**From:** [Archie](#)  
**To:** [A303 Stonehenge](#)  
**Subject:** Ref. Group A 20019736 - Morrison & King Limited  
**Date:** 03 May 2019 19:49:38  
**Attachments:** [MKL - Appendix One.pdf](#)  
[MKL - Appendix Three.pdf](#)  
[MKL - Appendix Four.pdf](#)  
[MKL - Appendix Five.pdf](#)

I refer to The Examining Authority's first Written Questions and requests for information (ExQ1) Issued on 11 April 2019. I represent Morrison & King Limited, a Tier One Landowner. In accordance with your examination timetable, I am submitting responses to the relevant questions as follows:

## **1. Proposed Site Compound**

APPENDIX THREE - ILLUSTRATIVE PLANS OF PROPOSED COMPOUND

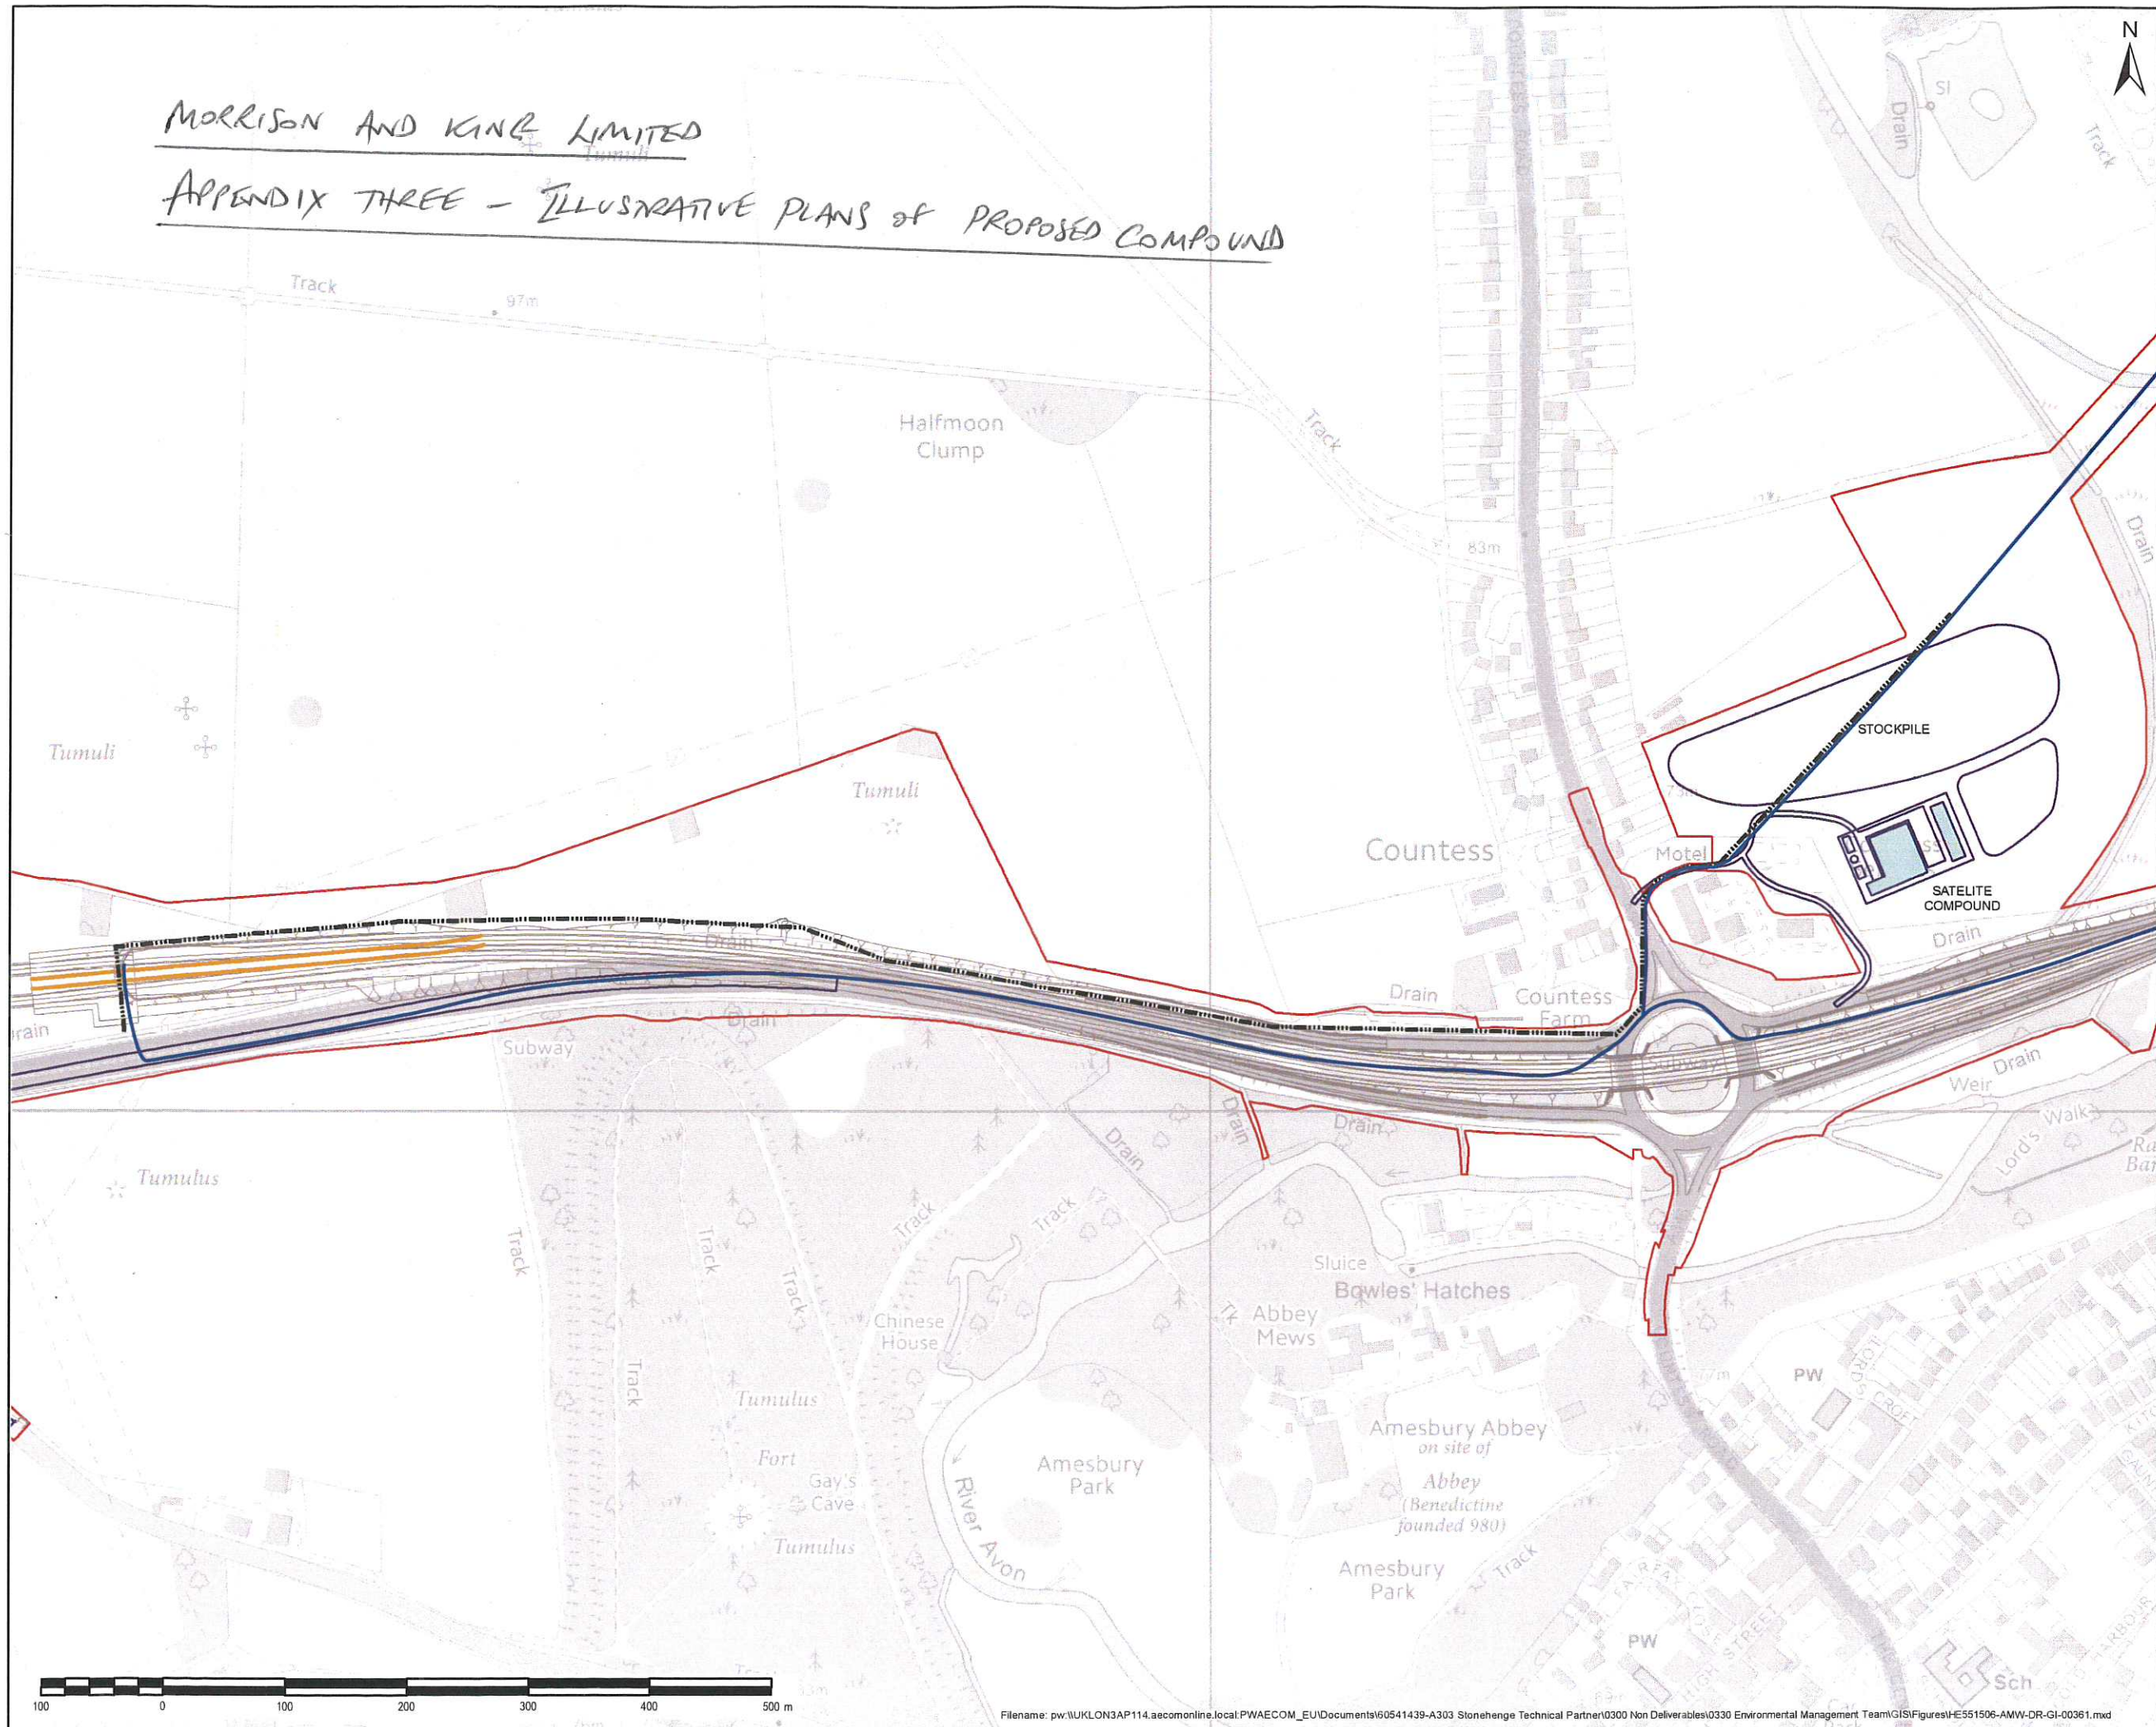
1.1. The level of detail provided by the Applicant relating to the proposed site compound on MKL's freehold has been woefully inadequate. Virtually the full extent of this is contained within the illustrative layout attached within Appendix Three. The self-same document raises more questions than it answers:

1.1.1. If there are to be extensive offices as shown where is the parking provision or are all workers expected to arrive by public transport?

1.1.2. This illustrative layout has been prepared to the same scale as the main compound within the same Appendix and this merely serves to underscore the vast scale of the stockpiles shown within the proposed site compound, estimated to cover in excess of nine acres. No explanation as to what these stockpiles will consist of has been forthcoming despite repeated enquiries of the Applicant. It seems almost inconceivable that an engineering project is proposing nine acres to be compulsory acquired for stockpiling and yet the detail of what is to be stockpiled is not available.

- 1.1.4. The illustrative layout referred to above shows a new water main being installed across the site; a site that is known to have archaeological interest. When questioned over this water main the Applicant explained that this was to be a water supply to the tunnel/main compound and it was therefore suggested that a better route might be found; one that did not require a crossing of the River Avon nor an area of known archaeological interest. It was subsequently revealed that this supply was for the proposed site compound on MKL's freehold and not the tunnel/main compound whatsoever, contrary to the detail within the illustrative layout. Surely as simpler and less disruptive supply could be taken from the main within Countess Road for that purpose?

APPENDIX FOUR - LOCATION OF LIVELY STABLES

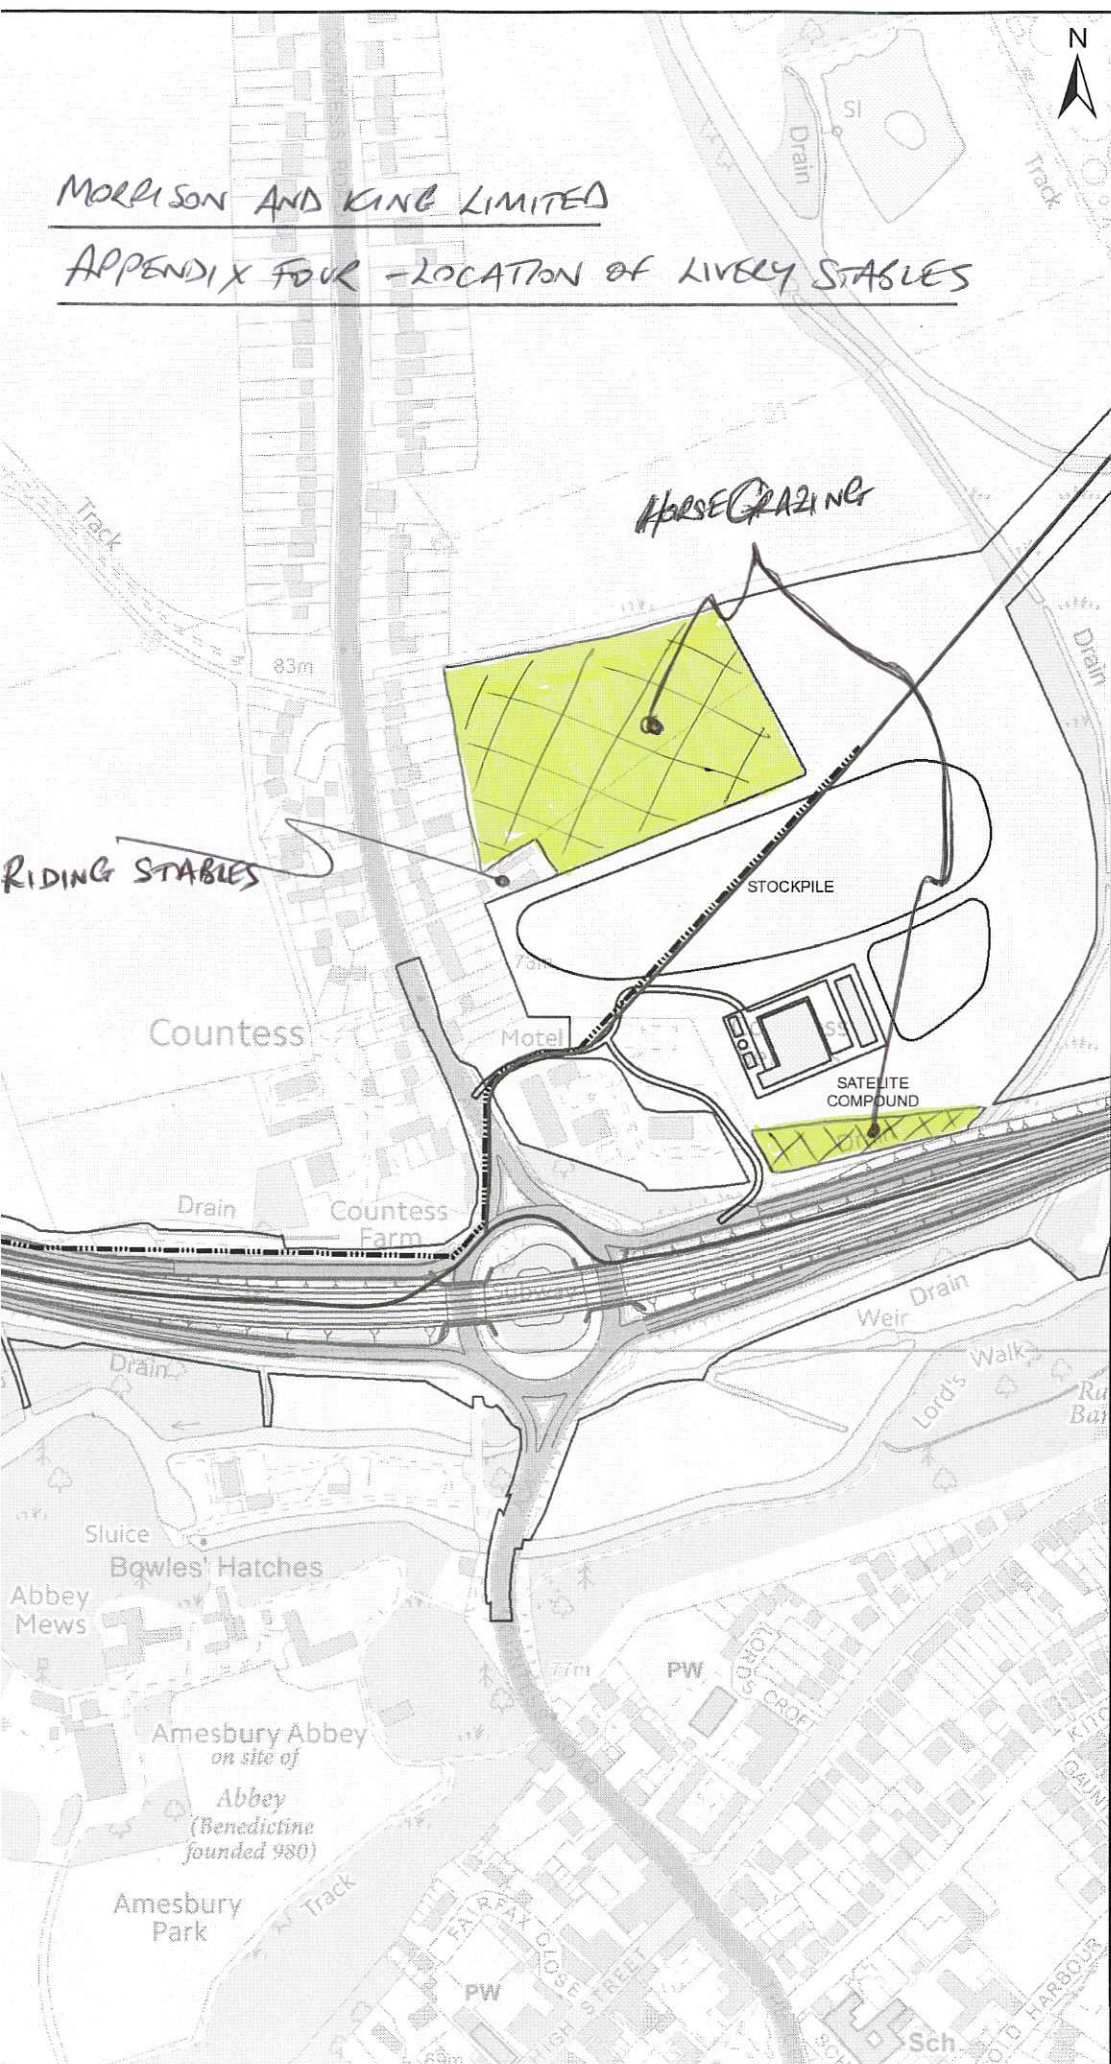
- 2.1. MKL has diversified its agricultural business by operating a horse livery enterprise out of a stable yard identified on the plan attached as Appendix Four. The stable yard consists of stables for a maximum of eight horses and an associated manège. The livery business utilises the grassland identified on the same plan. MKL supplies home produced hay and straw to this enterprise.
- 2.2. MKL has significant concerns regarding the likely disturbance to this enterprise arising from the Scheme. These concerns are fourfold as detailed below and insufficient detail has been provided by the Applicant to allay such concerns.

The location of the site compound immediately adjacent to the stable yard will undoubtedly lead to significantly increased levels of noise, dust and light intrusion. The Applicant has referenced the relevant topic chapters of the Environmental Statement, including Chapter 5, Air Quality (APP-043), Chapter 7 (APP-045), Landscape and Visual, Chapter 9 APP-047), Noise and Vibration, and Chapter 13 (APP-051), People and Communities (document reference 6.1). These assessments have concluded that there would be a range of adverse impacts during construction, presumably the entire period that the site compound is located adjacent to the stable yard.

Security at livery yards is extremely important, as they are frequently the target for low level rural crime. Potential clients looking for livery are highly sensitive to any perceived 'security threats' where they may be considering stabling their horse. It is hard to imagine that a large and active adjoining site compound would not have an adverse impact upon the perception of yard security whether any actual crime were to arise or not.
